24 October 2018

**Genesis Waste Management Facility Modification 6 (MP 06_0139 MOD 6)
Submission on behalf of Jacfin Pty Ltd – Hours of Operation and Landfill Cap**

This submission is made on behalf of Jacfin in relation to the application by Dial a Dump Industries (EC) Pty Limited to modify the hours of operation and landfill cap applicable to the Facility (MP 06_0139 MOD 6) (**Modification Application**). We note that a preliminary submission on behalf of our client was provided on Wednesday, 17 October 2018. The Department confirmed by email on 16 October 2018 that Jacfin was granted an extension of time to make a further detailed submission until 24 October 2018.

Figure A5-6: Predicted Project-only annual average dust deposition (g/m²/month)

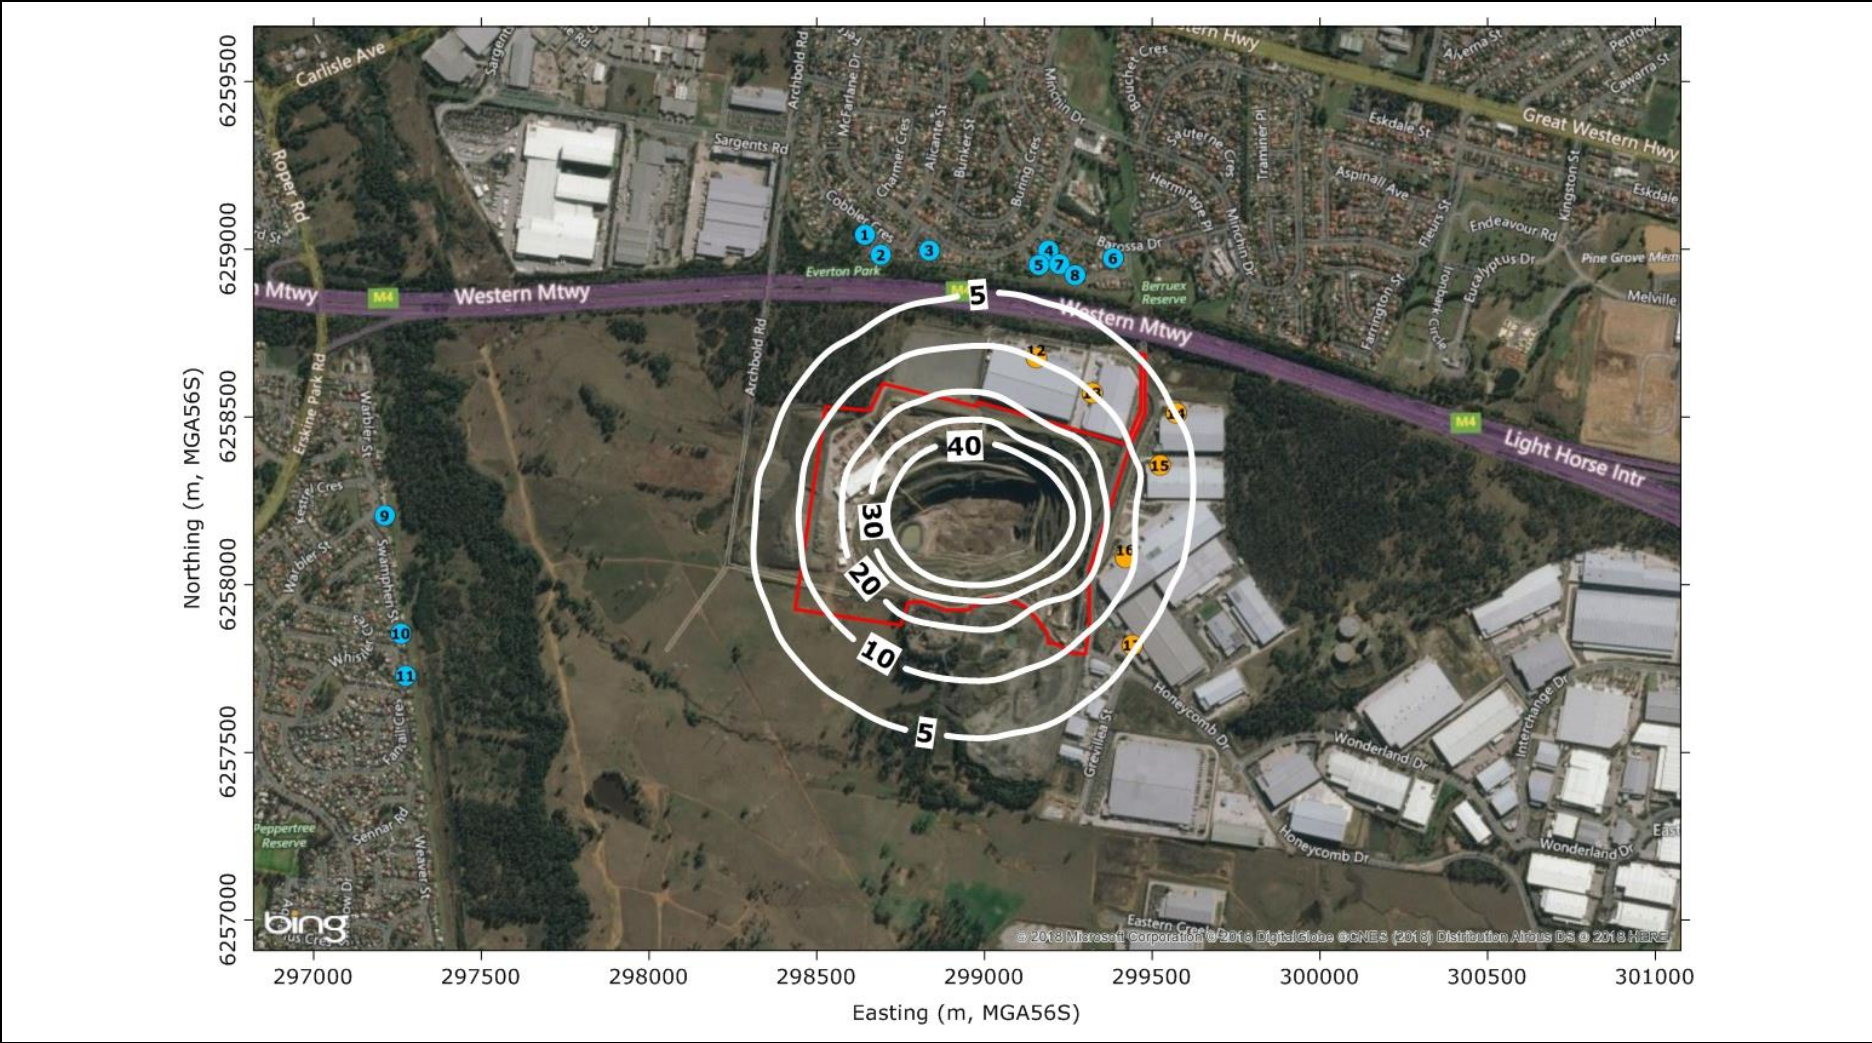
- (f) There appear to be inaccuracies in the dust deposition rate contour plot at Figure A5-6 of the Air Quality Assessment and these figures are not representative of the potential impact of the Modification Application.
